HINCKLEY RAIL FREIGHT TERMINAL

Summary: Transport and Access

CPRE Leicestershire

Oct 2023

Document reference: 18.6.9

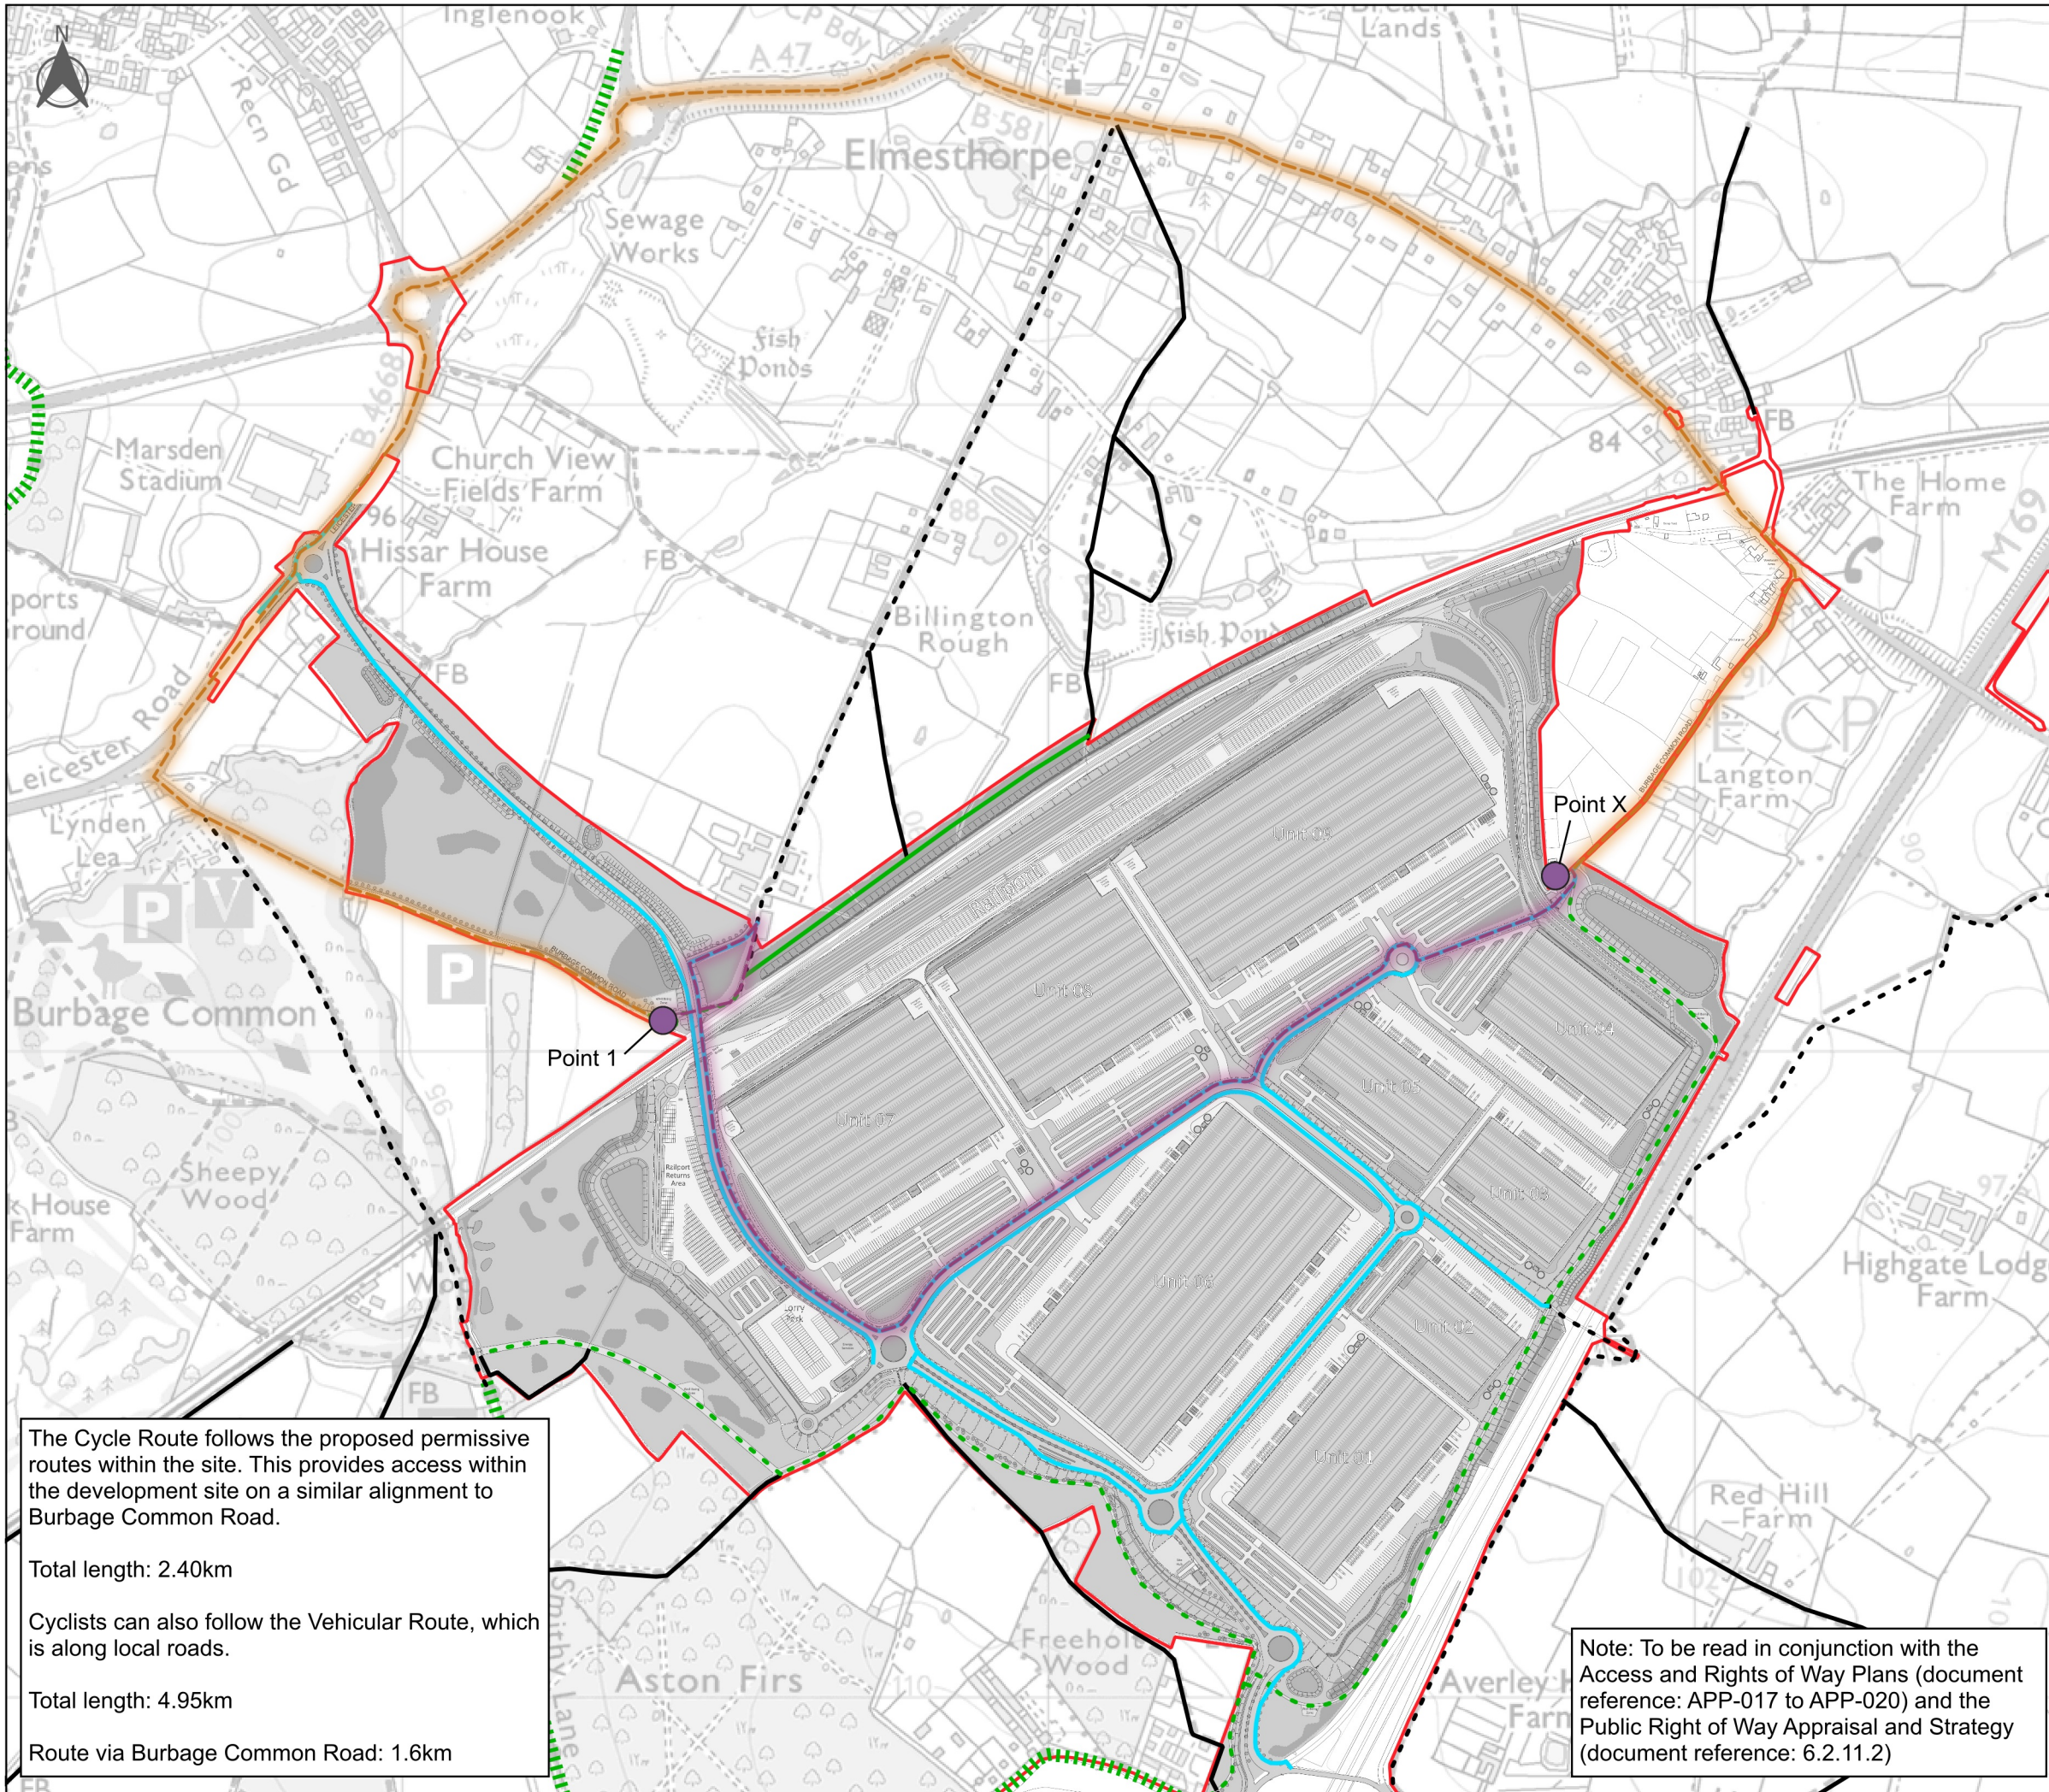
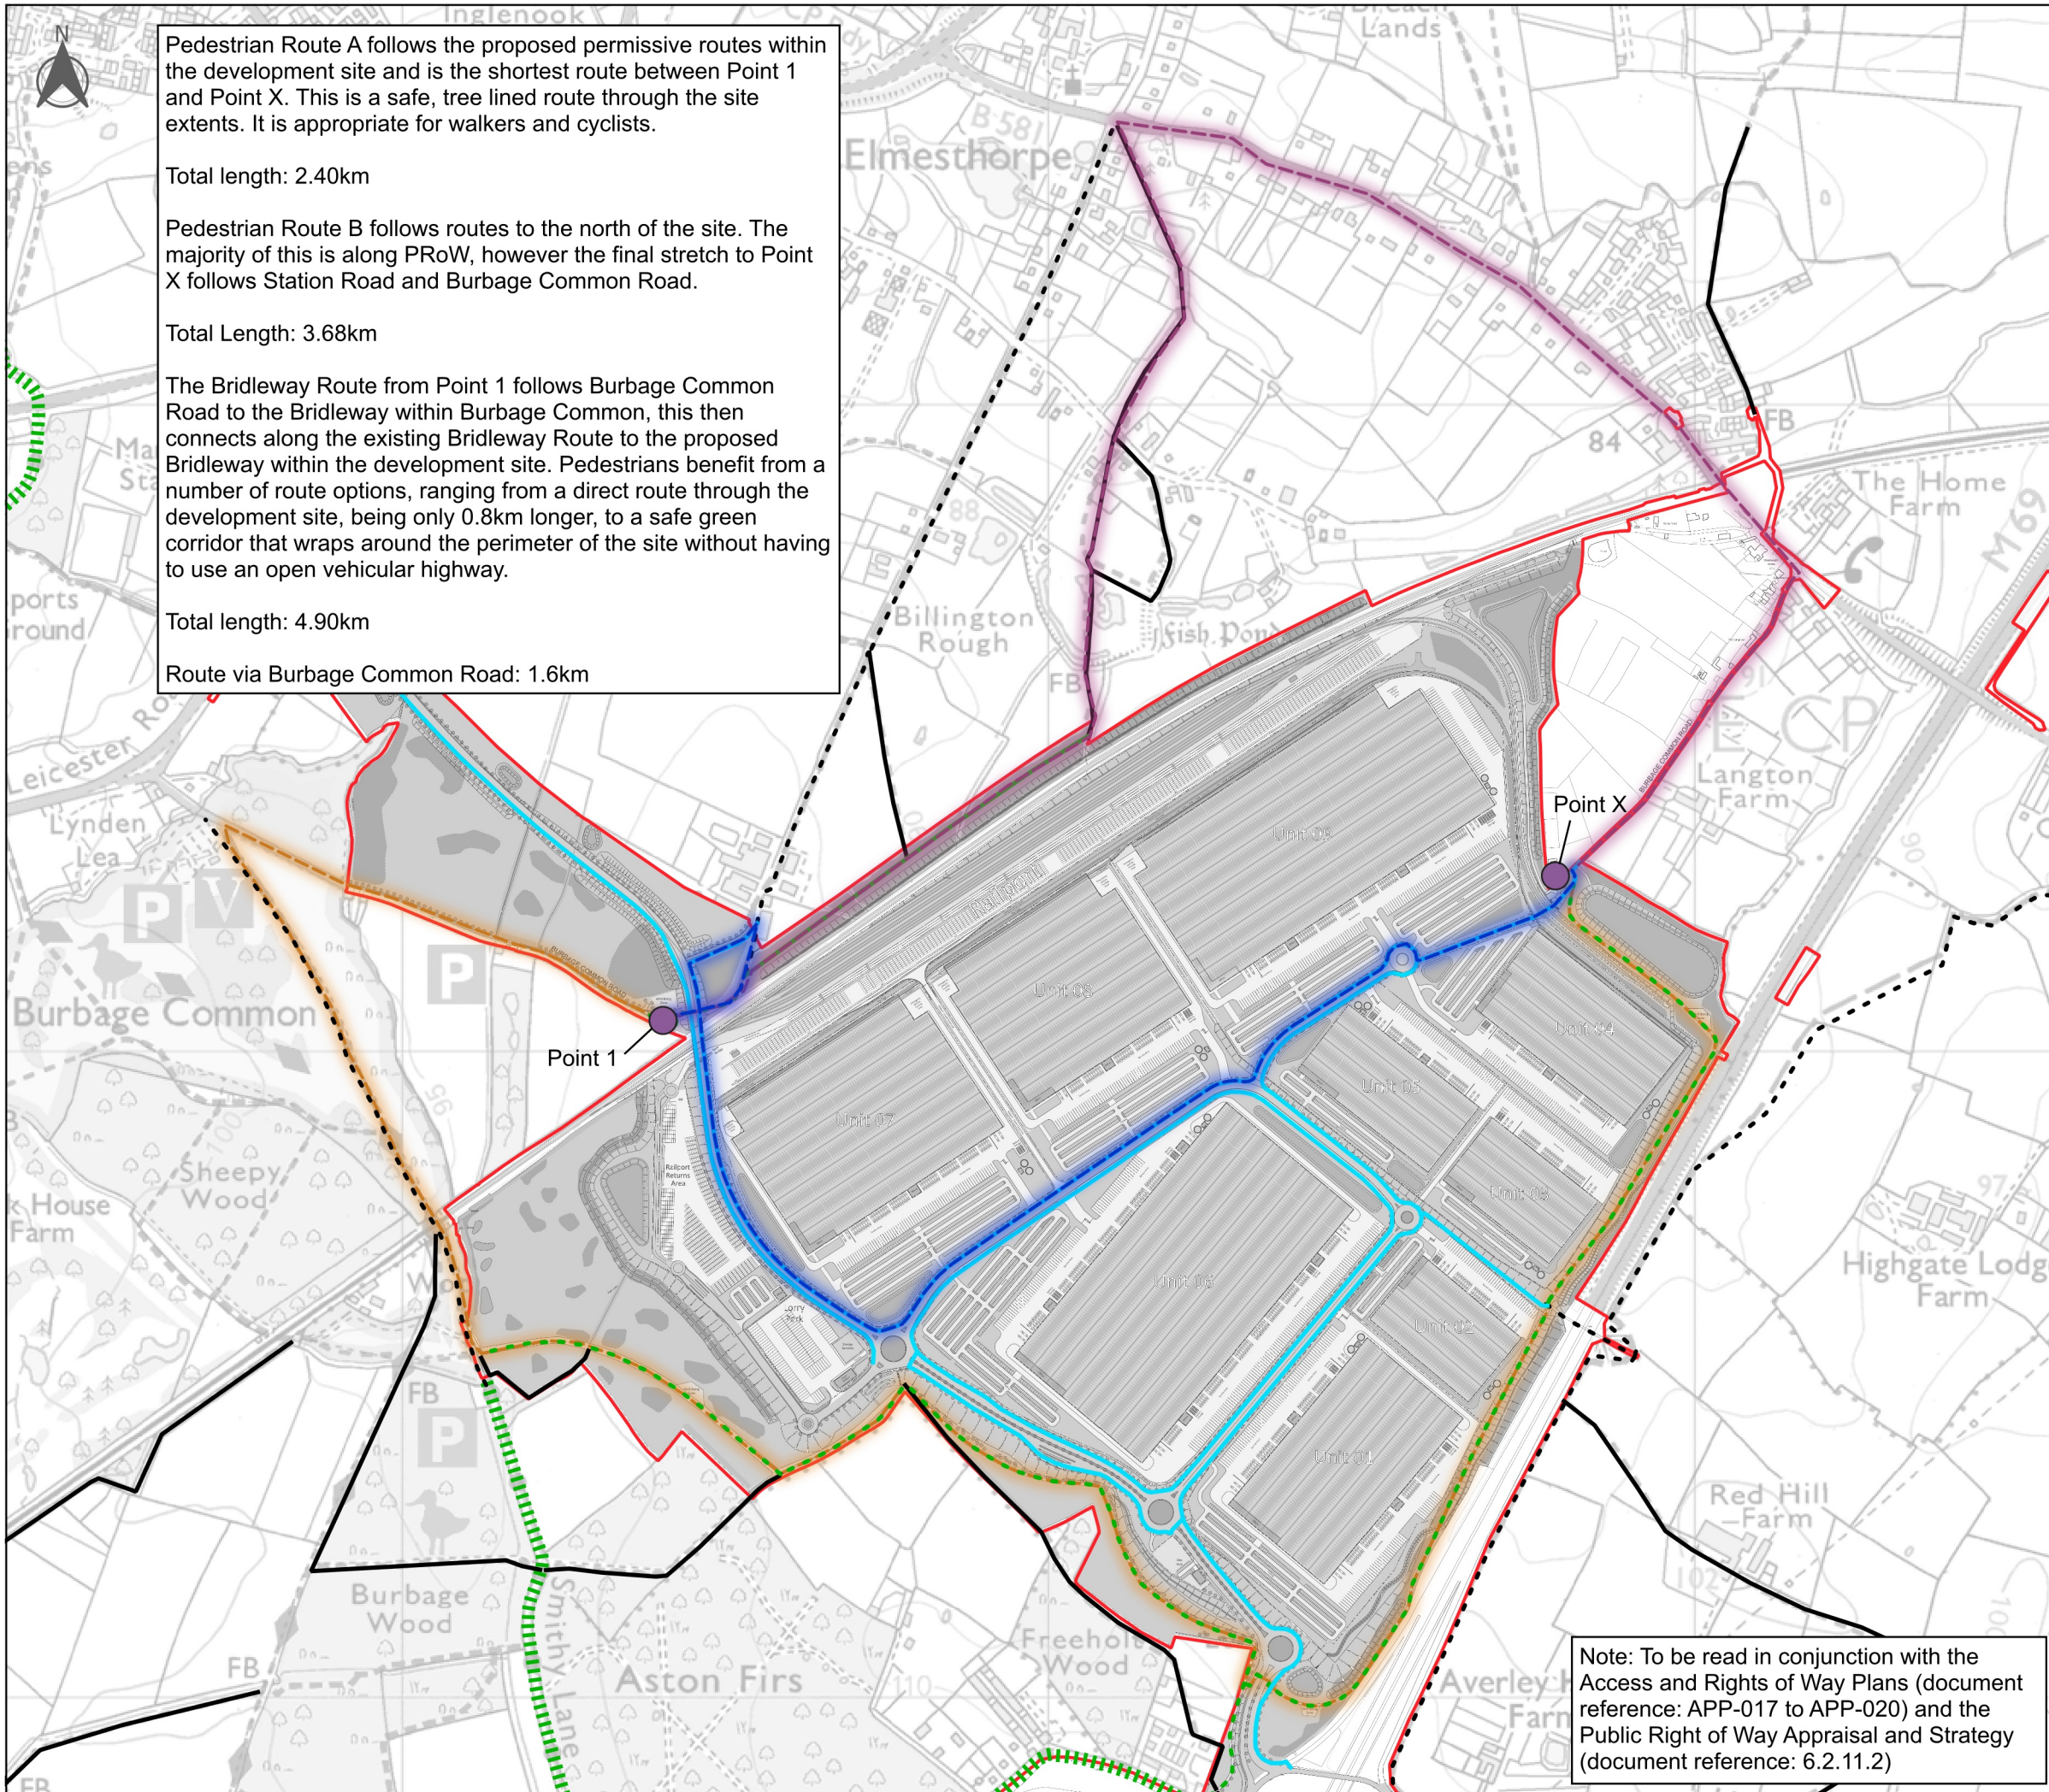
8.2.3 The Assessment paints a glossy picture of potential improvements to the PROW network which is curtailed drastically between Hinckley and the motorway, as well as losing the opportunity to walk on the quiet Burbage Road. Pedestrians are forced onto the newly-constructed link road, then through the Industrial Park, or on a circuitous bridleway around the proposals. None would enjoy the attractiveness of the current routes through open countryside.

8.2.4 Equally, residents of Stoney Stanton, Sapcote and Sharnford would find the PROW links to Burbage Common restricted in quantity and quality.
